**Planning Application 21/01224/OUT**  
**Cherwell Local Plan Policy ESD10 and National Policy as conveyed by NPPF 180**

**Critique of BNG calculations submitted by Ecology Solutions**

Bioscan have been instructed by CPRE to carry out a rapid review of the Biodiversity Net Gain calculations submitted by the applicant, Bicester Motion, in support of the above application.

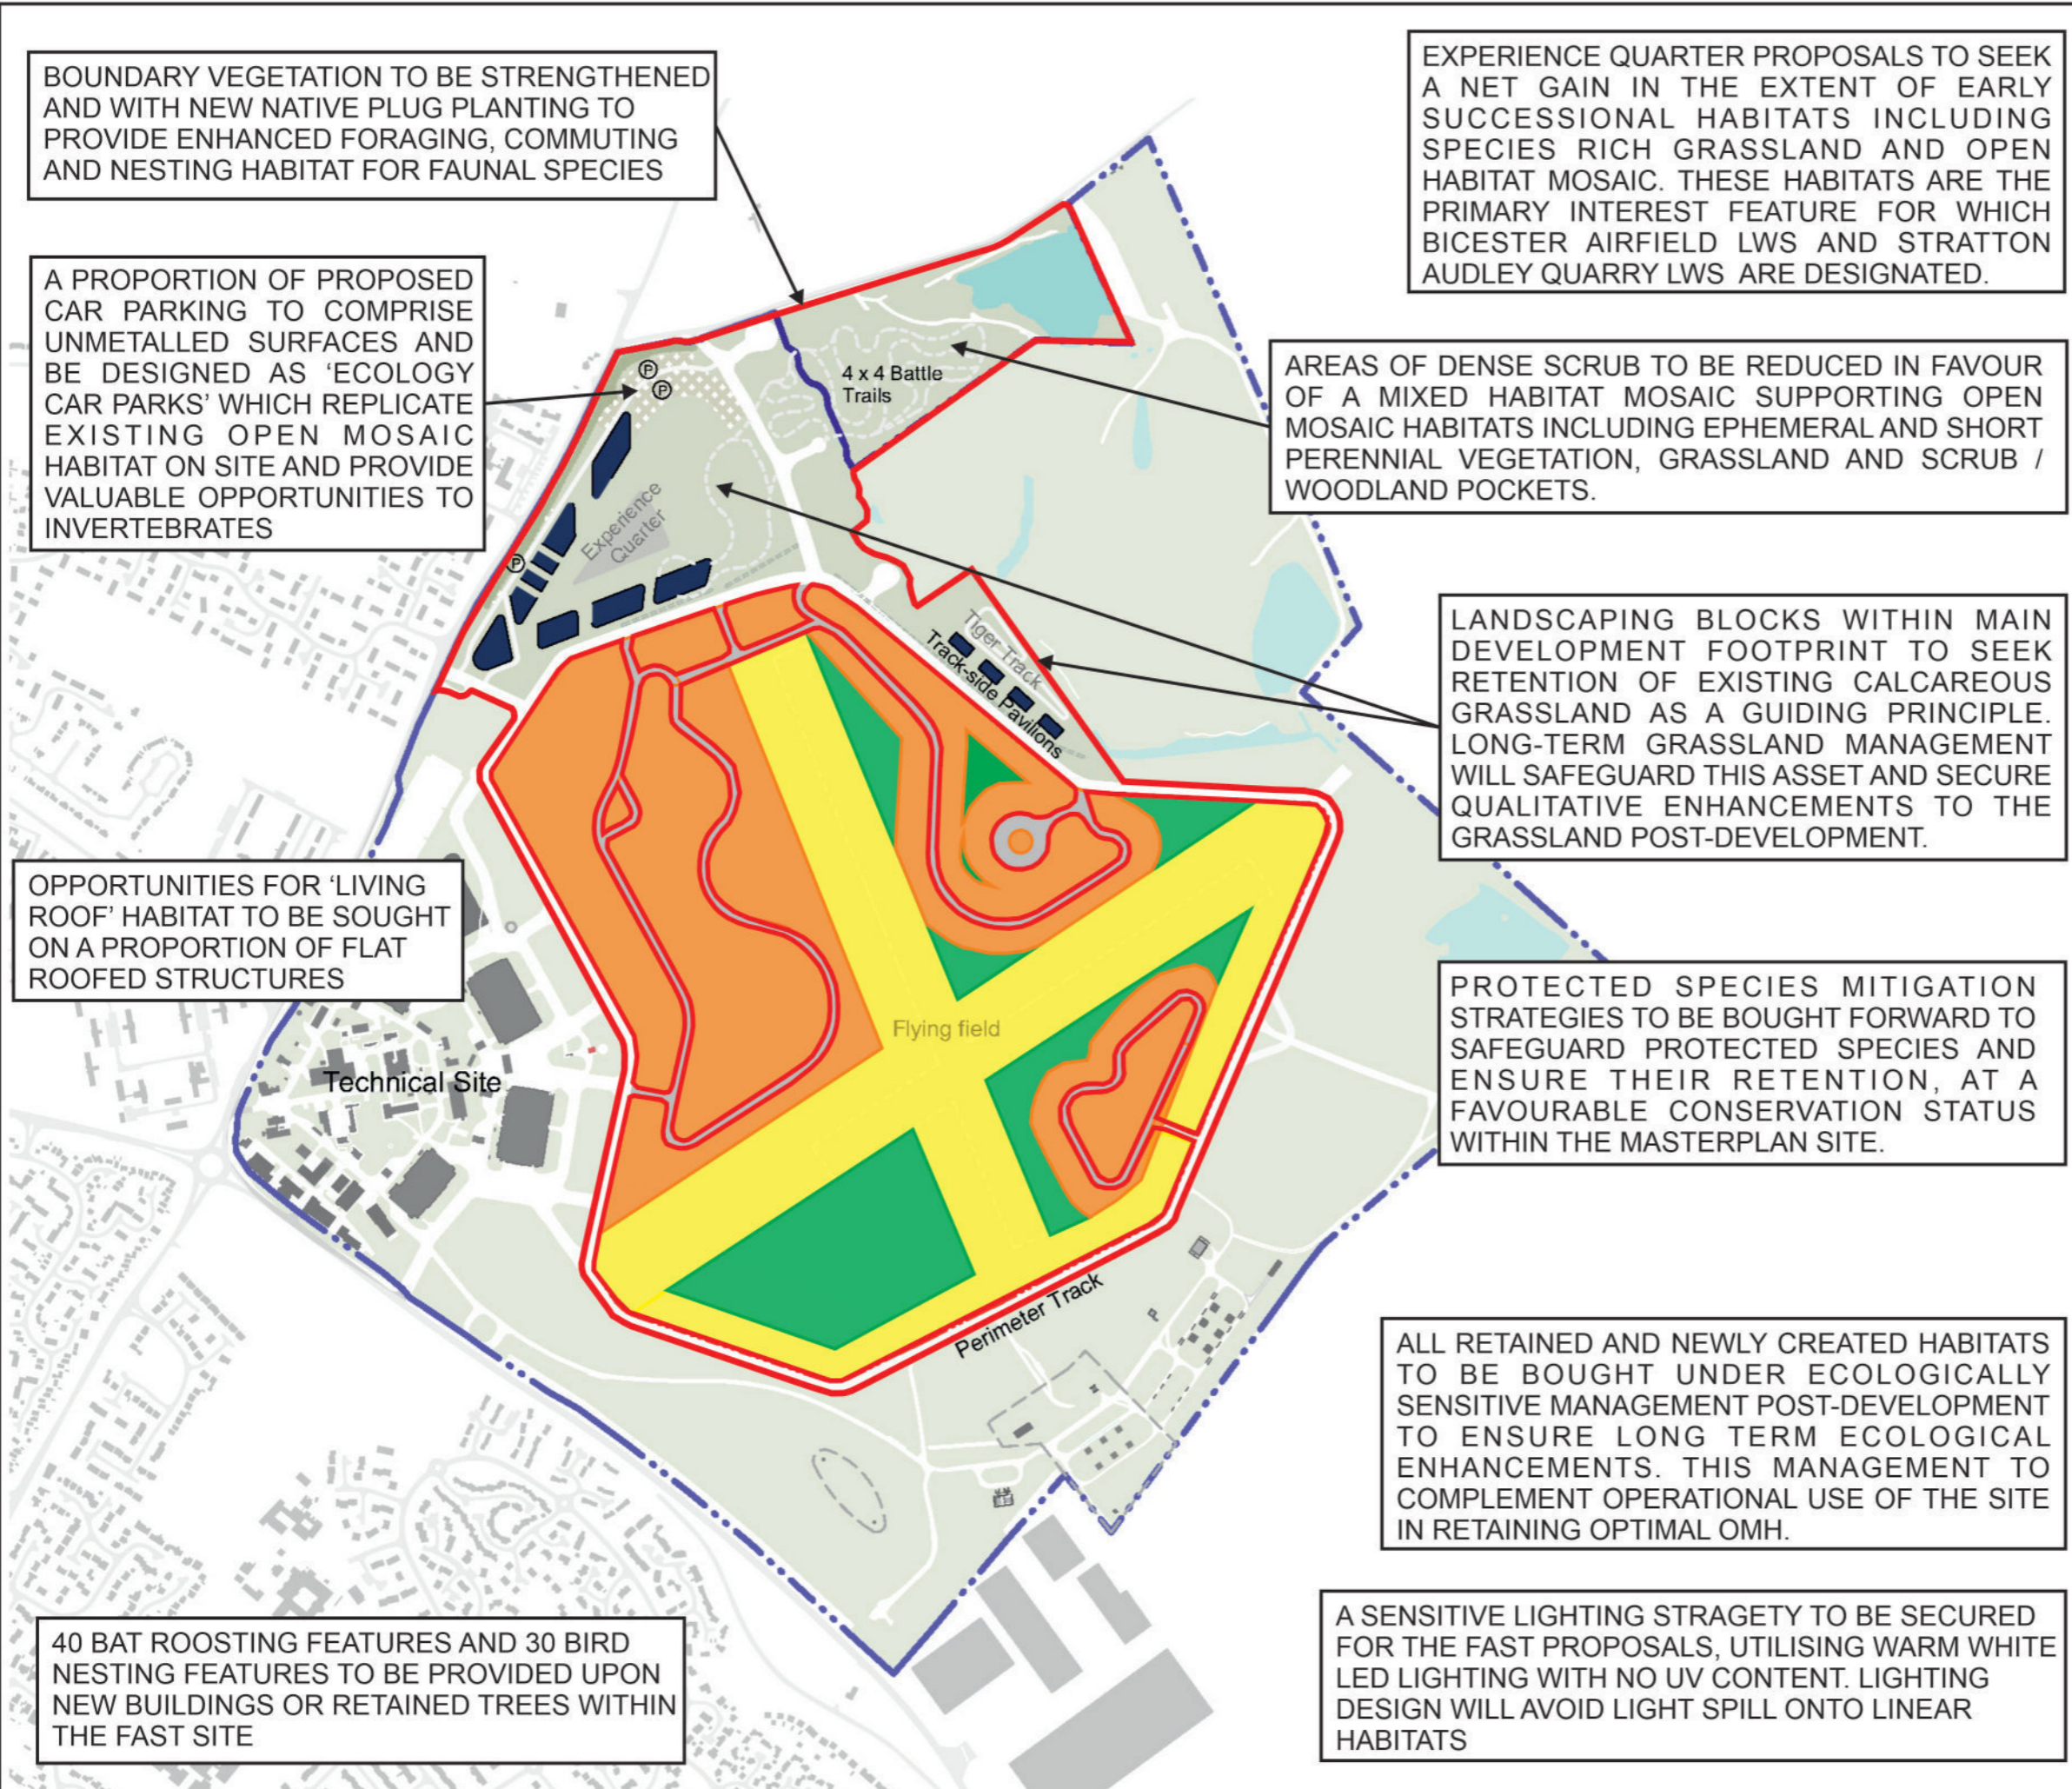
- One possibility is that use of Metric 3.0 has been eschewed by the applicants because it delivers a poorer result. This has been tested by populating Natural England’s Metric 3.0 calculator with the applicant’s inputs for the area-based calculations as taken from their Warwickshire calculator.
- The result of this exercise is indicated by the summary output below – Metric 3.0 indicates that this development does not deliver 10% net gain and indeed (given standard 5% margins of error) may well deliver net loss even using the applicants’ own figures. Use of Metric 3.0 also flags that trading rules (intended to avoid high quality habitats being traded for larger quantities of lower quality ones) have not been satisfied.

- Over and above this issue, and in the event the Warwickshire calculator was deemed to be satisfactory for decision making, the reliability of the applicant’s input figures is open to very serious question. Analysis of the applicant’s calculations reveals that the case for avoiding net loss and delivering net gain hinges in large part on a particular proposed habitat change. This is the proposed delivery of a very large quantum (26.27ha) of high distinctiveness<sup>2</sup> open mosaic habitat (OMH) – indeed of a value equivalent to ‘Priority’ representations of this type of habitat as are sometimes found on long-abandoned industrial and minerals sites. On any sober technical and real-world analysis, this is an extremely unlikely outcome. For example, if high distinctiveness OMH was capable of being delivered on this site (as a function of substrates, ground conditions and other factors), it would

already be present in the areas already identified as colonising disturbed ground. Yet no such high distinctiveness examples are indicated in the baseline calculations. The applicant's case is that in the future, the more intensive uses of part of the site will somehow deliver a huge uplift in the quality of areas of ground disturbed by development, car-parking and motorsport activities, to the point at which they attain a structure, composition and value equivalent to the Priority habitat type. This is unevidenced, and nor can it be evidenced. The attached photographs convey the gulf of reality between what the applicants are claiming will be the result of ground disturbance from motorsport and car parking activities, and high distinctiveness open mosaic habitat. The reality is that the disturbed ground from vehicular and other activities in the operational phase will deliver habitats no better, and in all probability substantially worse, than the current neglected and/or disturbed areas on the site at present, and in any event much poorer than the medium-high distinctiveness semi-improved calcareous grasslands that they will in large part replace. Making a simple correction to the calculations to account for this more realistic outcome results in a net loss of -121.62 habitat units, equating to -9.59% net loss, per the below. This is a much more realistic BNG calculation.

7. Thus, by far the more robust assessment of the long-term effect of the proposed development is that it will deliver upwards of 10% **net loss** due to the amount of high value calcareous grassland habitat that will be lost both to development and to operational activities. The applicant's own calculations carry an error message indicating that impacts unacceptable in policy terms will arise and independent review of those calculations using a more up to date metric further supports the case that these proposals result in an extent of habitat loss and damage that does not comply with local or national planning policy related to biodiversity and development.
